Aughton Bailey and Chaigley Parish Council
c/o 17 Smithy Row
Hurst Green
Clitheroe
BB7 9QA
Email: clerk@aughtonbaileyandchaigley-pc.gov.uk
07921472172

30th June 2026

Planning Application No: 3/2026/0246 Grid Ref: 366831 438350 Proposal: Retrospective planning permission for works to an existing agricultural building to include: alterations to building footprint, alterations to existing roof from mono-pitched to dual pitched, increase in roof ridge height, alterations to existing openings. Proposed installation of soft landscaping Location: Land at Lower Hud Lee Farm Longridge Road Hurst Green BB7 9QP

A Holt – Land at Lower Hud Lee Farm – Floor and Roof Plan 5

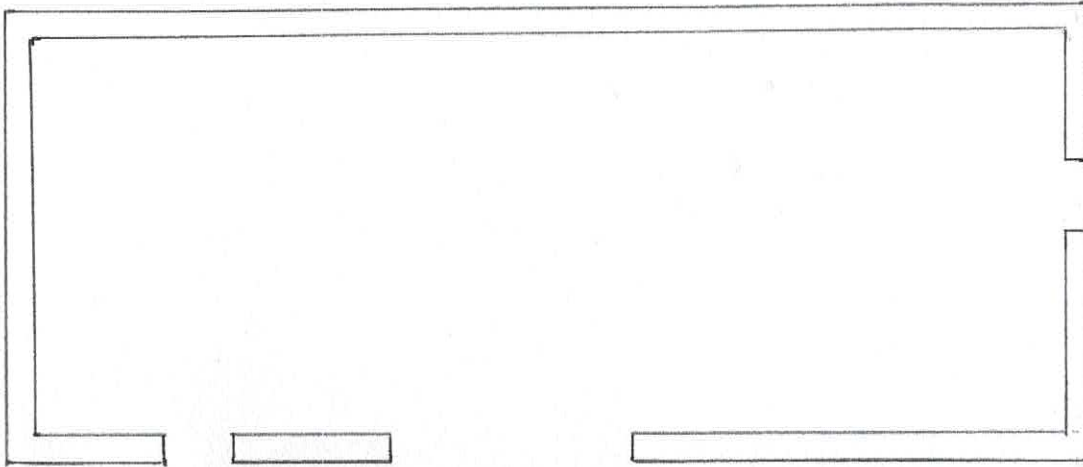
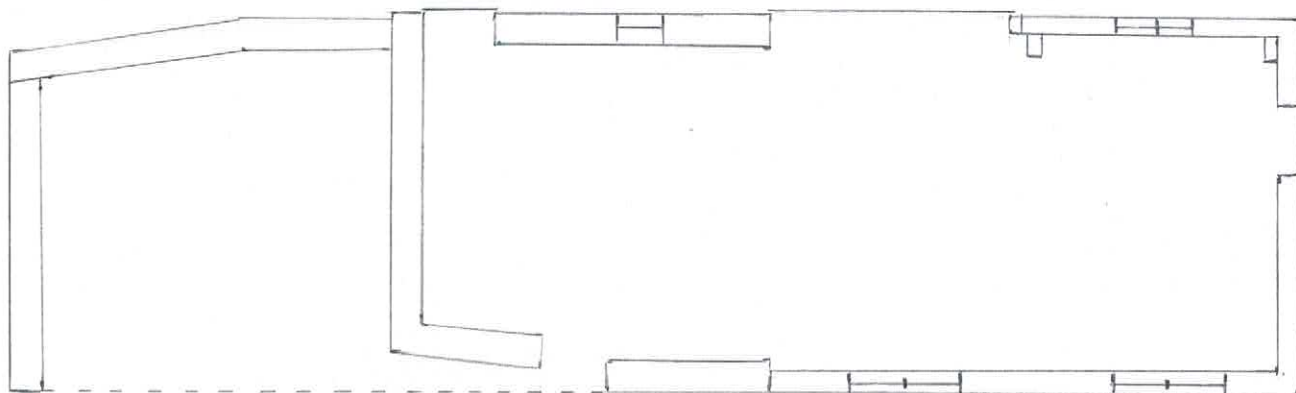
1. That they have no objection to this permission provided the building remains as an agricultural site in future.
2. The building was considered to be redundant for some time and it now appears that this permission creates a substantially larger footprint.
3. The council would like to state that they would not be in favour of any future requests to the RVBC for the newly completed farm buildings to be converted to habitable occupation.
4. There is a substantial agricultural structure already existing within the curtilage of the farm.
